Recommendation Report for Lawful Development Certificate for a Proposed Use or Development**REF NO:** BR/279/20/CLP**LOCATION:** Holly Holm
Sylvan Way
Bognor Regis
PO21 2RS**PROPOSAL:** Lawful development certificate for the Proposed installation of 24No. Solar panels on flat roof of existing conservatory.**DESCRIPTION OF APPLICATION**

This application seeks the installation of 24 solar (pv) panels to flat roof.

<div>American projection:  VAN DER VALK  SOLAR SYSTEMS www.valksolarsystems.nl</div>	Scale: 1 : 40	Author: Robin	Comments:	
	Unit: mm	Group:		
	Material:	Date: 19-12-2017		
	Project:	Side view drawing		Rev: State:
Description: ValkPro+ L10 - East-West		Part number.:		Size: A3

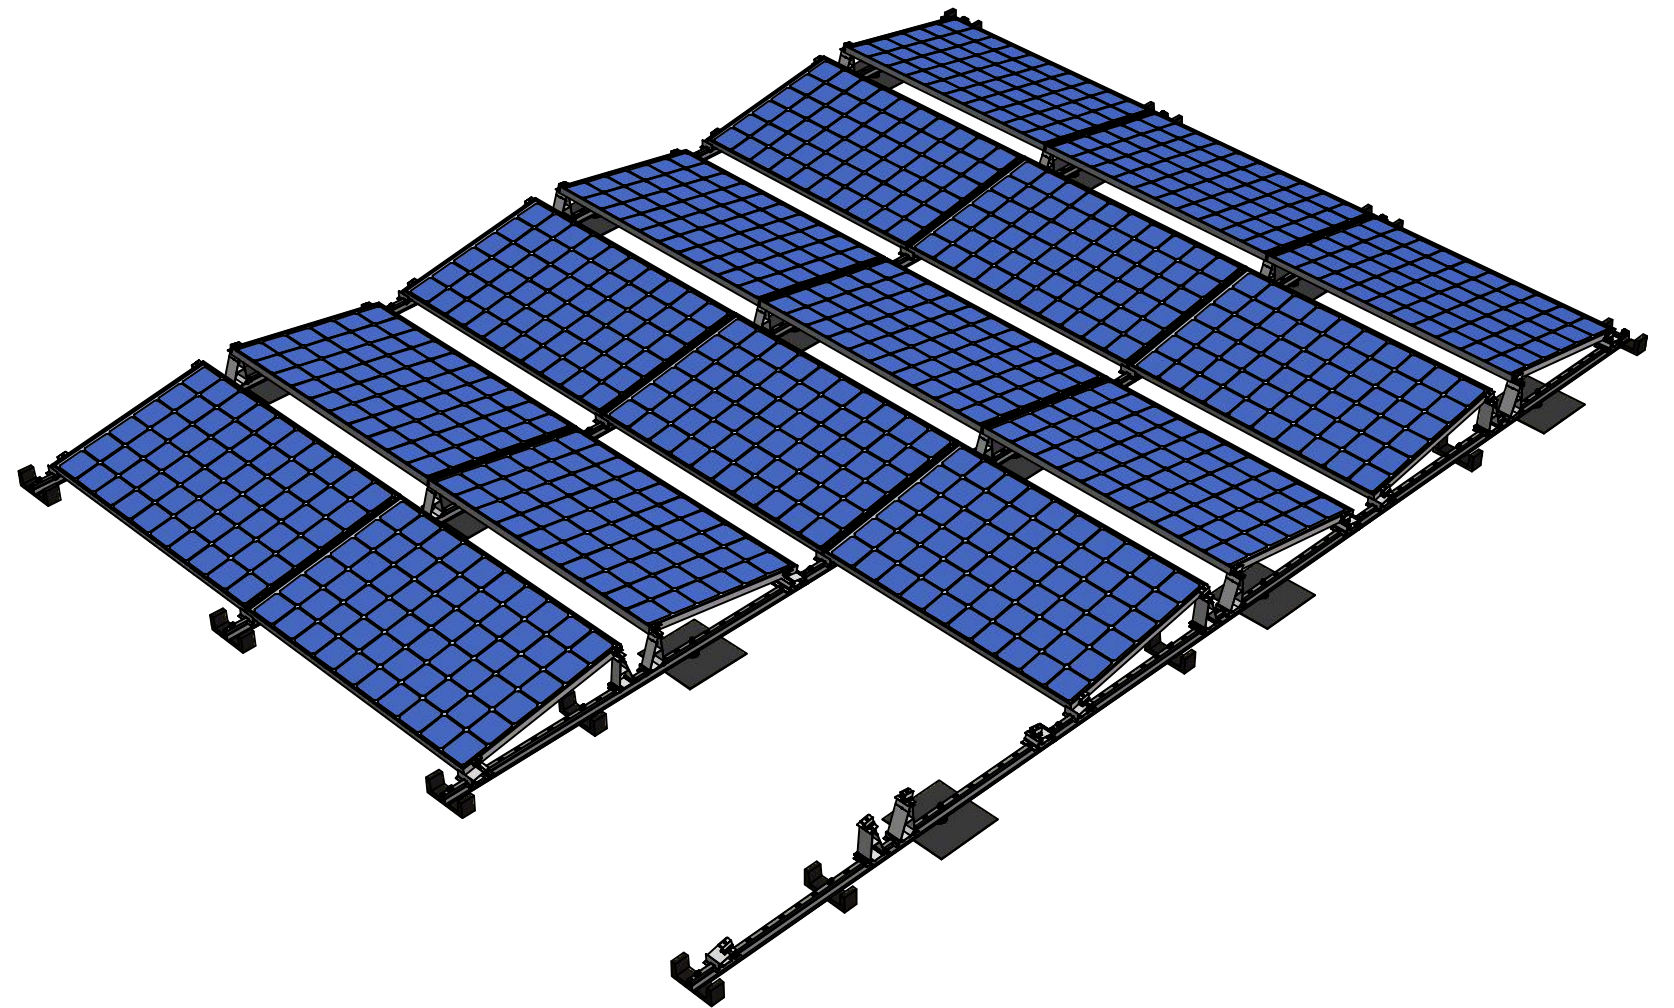
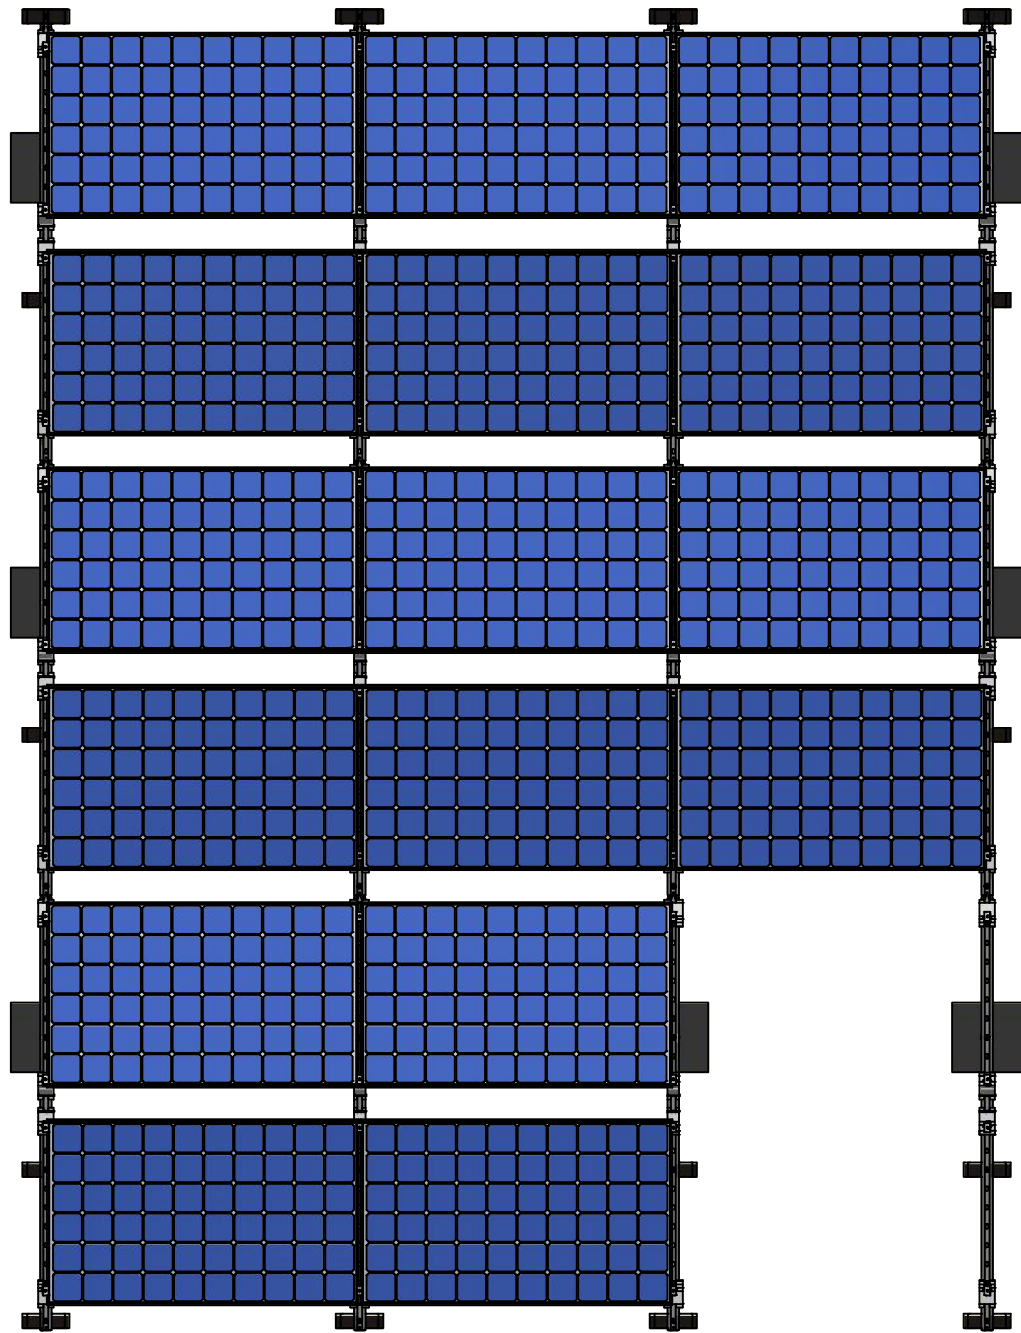
The proposed installation of 24 solar panels conflicts with the relevant section (a) as it exceed the allowance to extend beyond the surface of the roof plane and therefore requires the submission of a full planning application.
